re Application R/239/20/PDM
17, Amberley Road, Rustington, BN 16 2EF.

Thank you for the information regarding the proposed extension of a conservatory at the above address. I have seen the plans.

Conservatory Proposal for

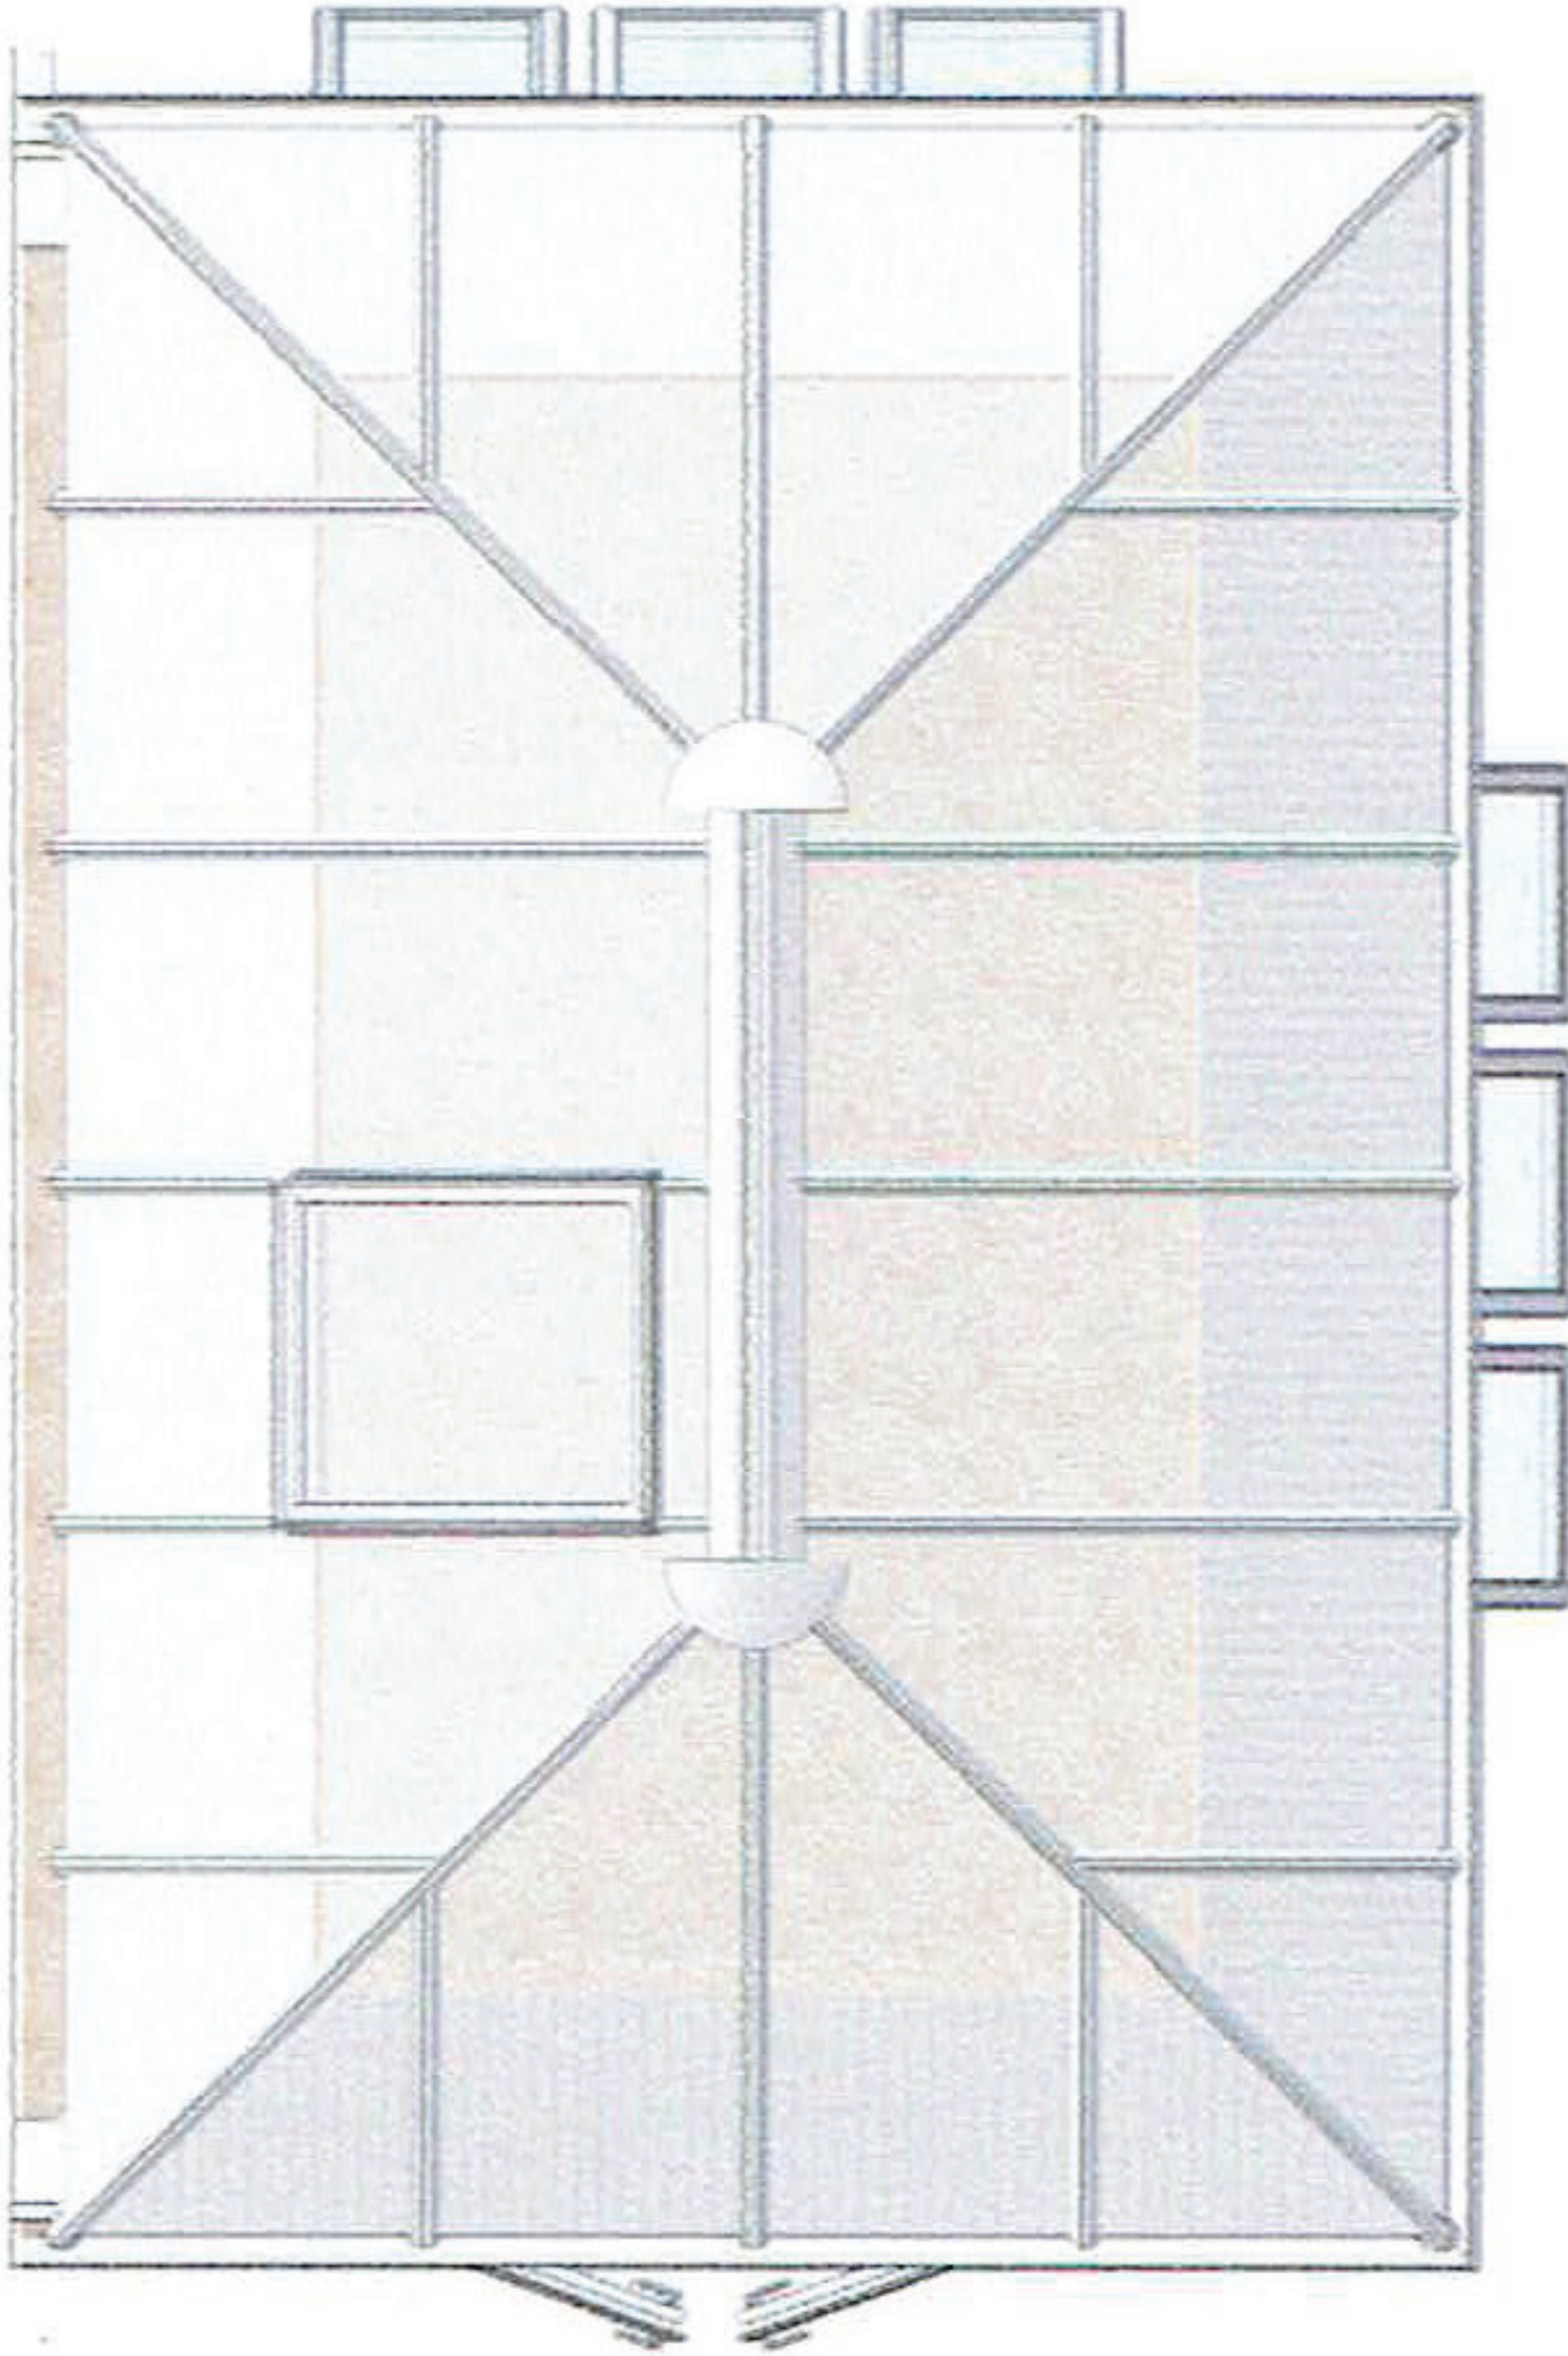
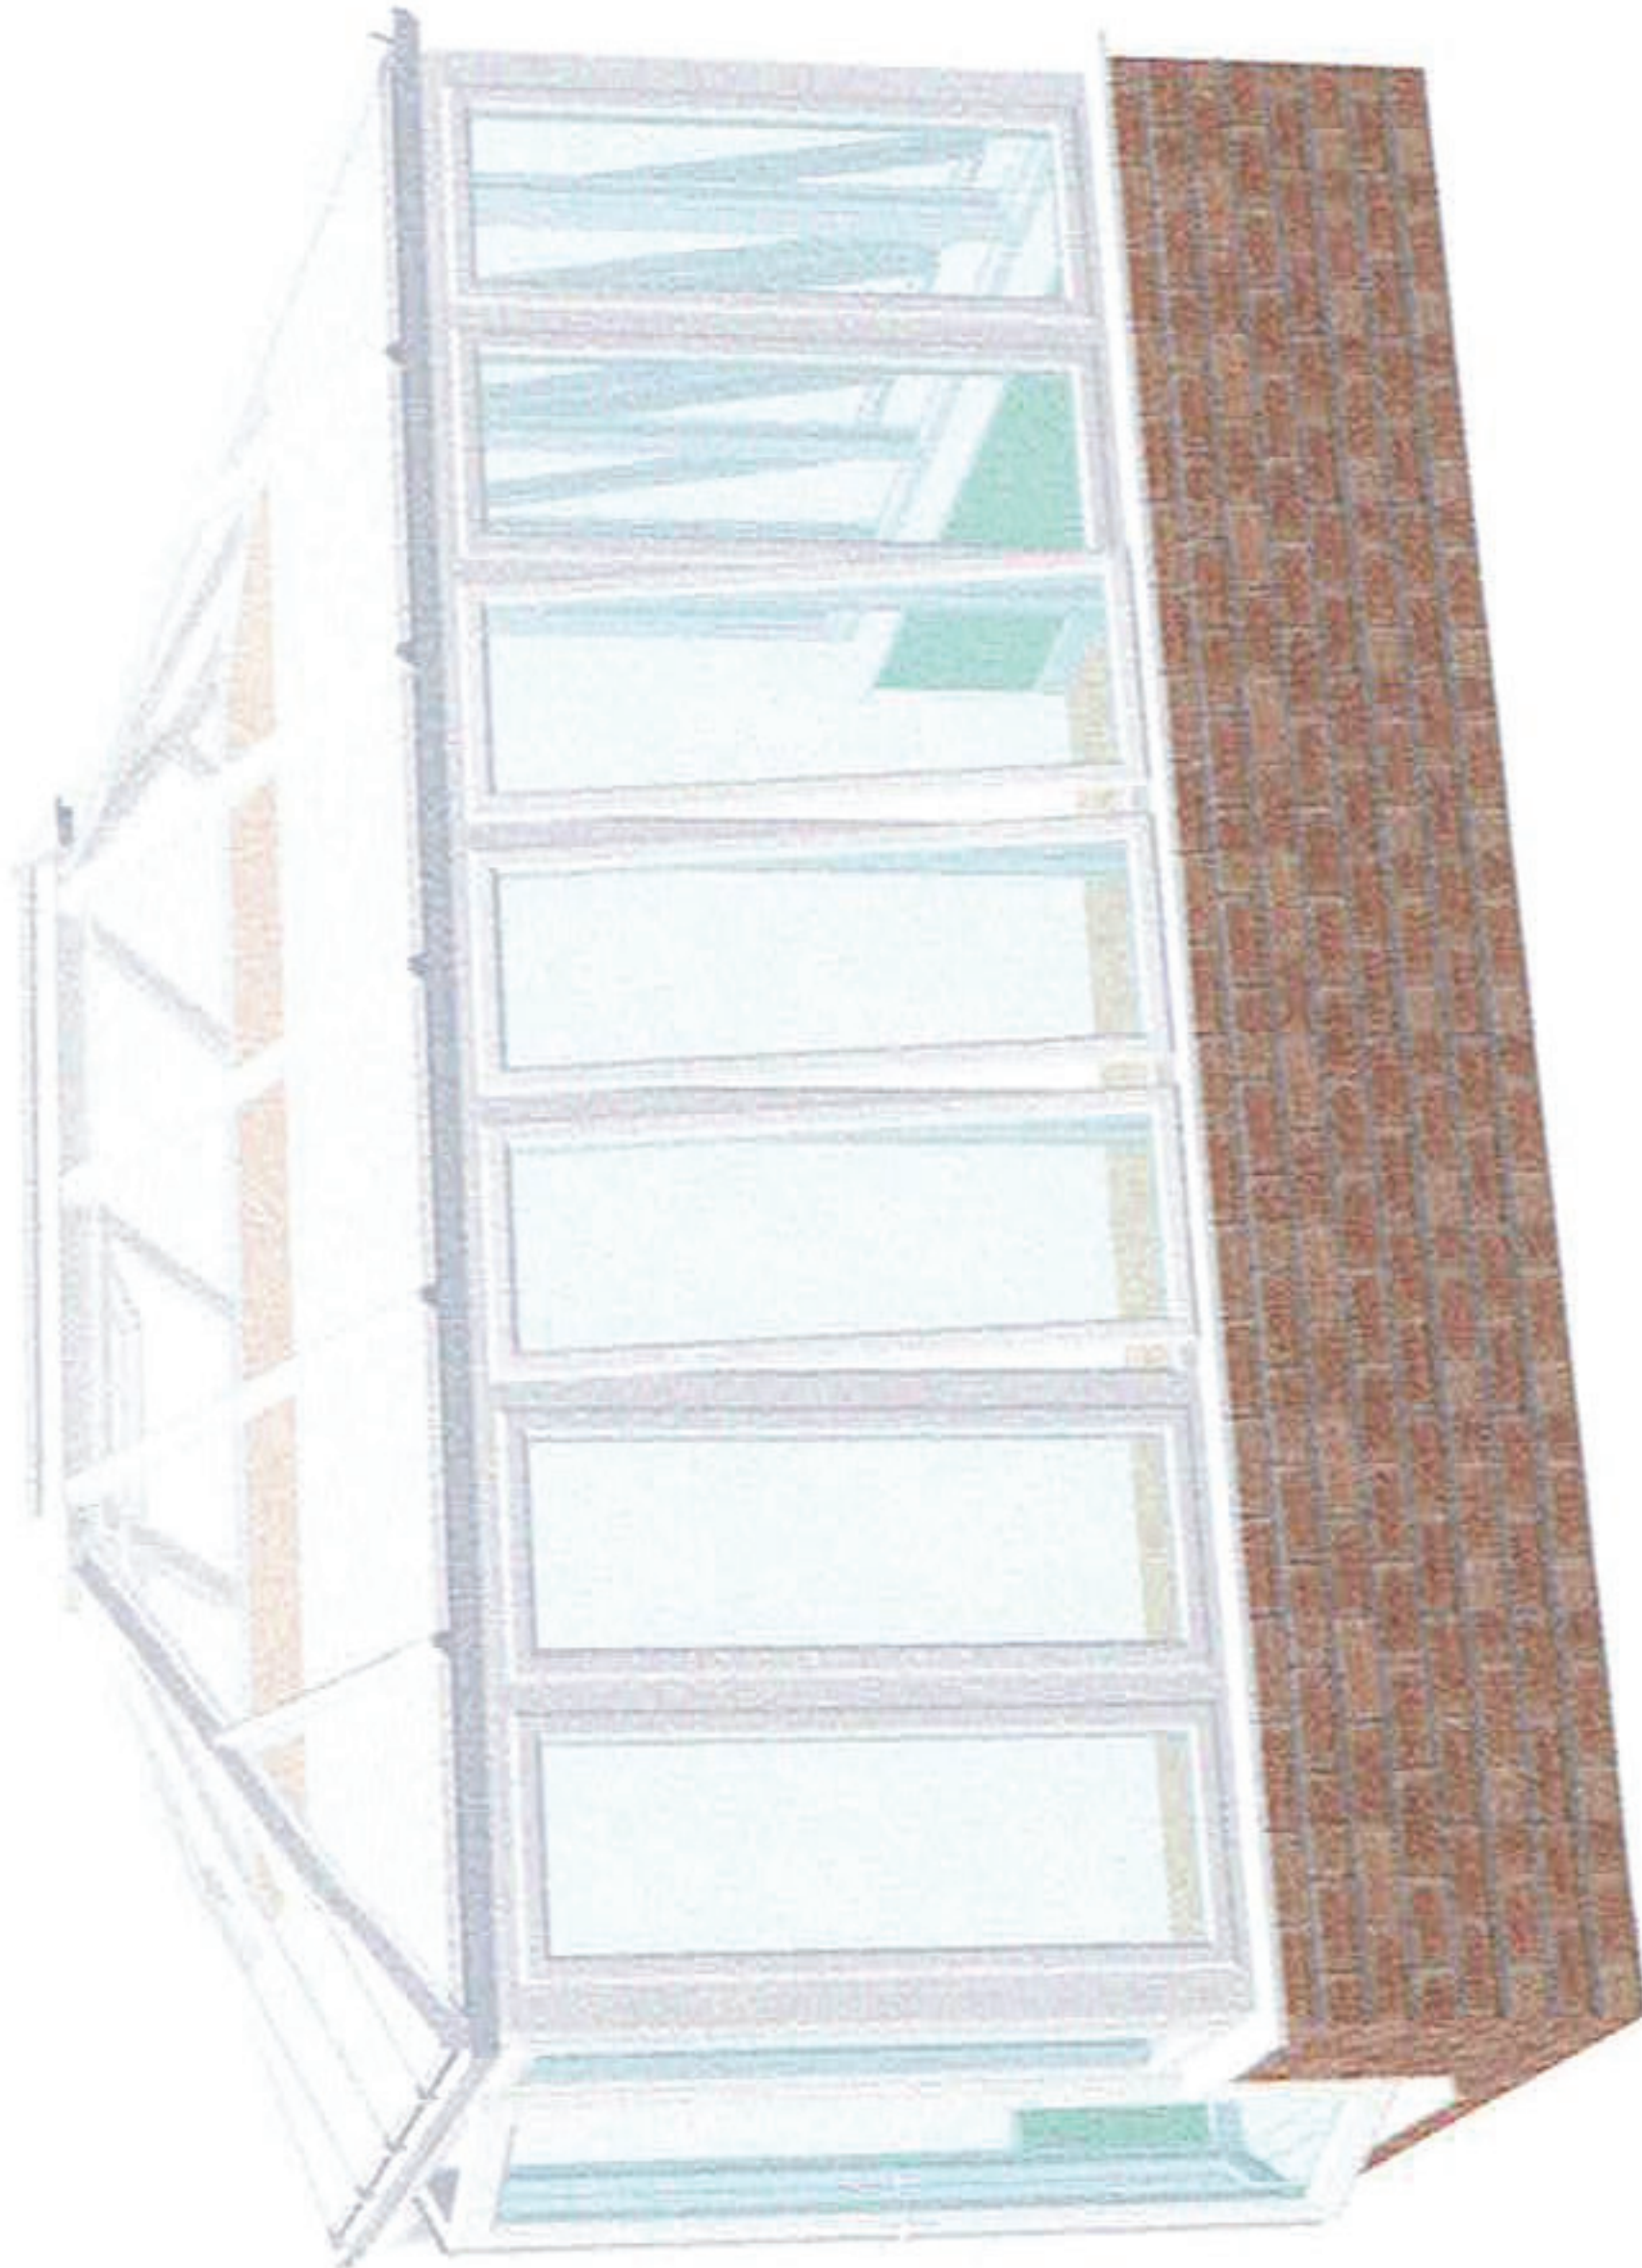
The property lies directly behind ours & already has a very substantial full width extension which appears to have eaves higher than the original bungalow. I don't know if this is actually the case.

Although I feel I cannot object in principle, the proposed size, & particularly height, of the building does greatly concern me. It would adversely impact on our property, especially as in recent weeks all the previously screening vegetation (cherry trees & camellias) have been removed.

If the roof of the proposed conservatory were to be kept at eaves height, & not the extra 0.92 metres, this would be much more acceptable. It would also be more in keeping with the style of the property.

Please can this be put forward as a condition of granting permission? We request this
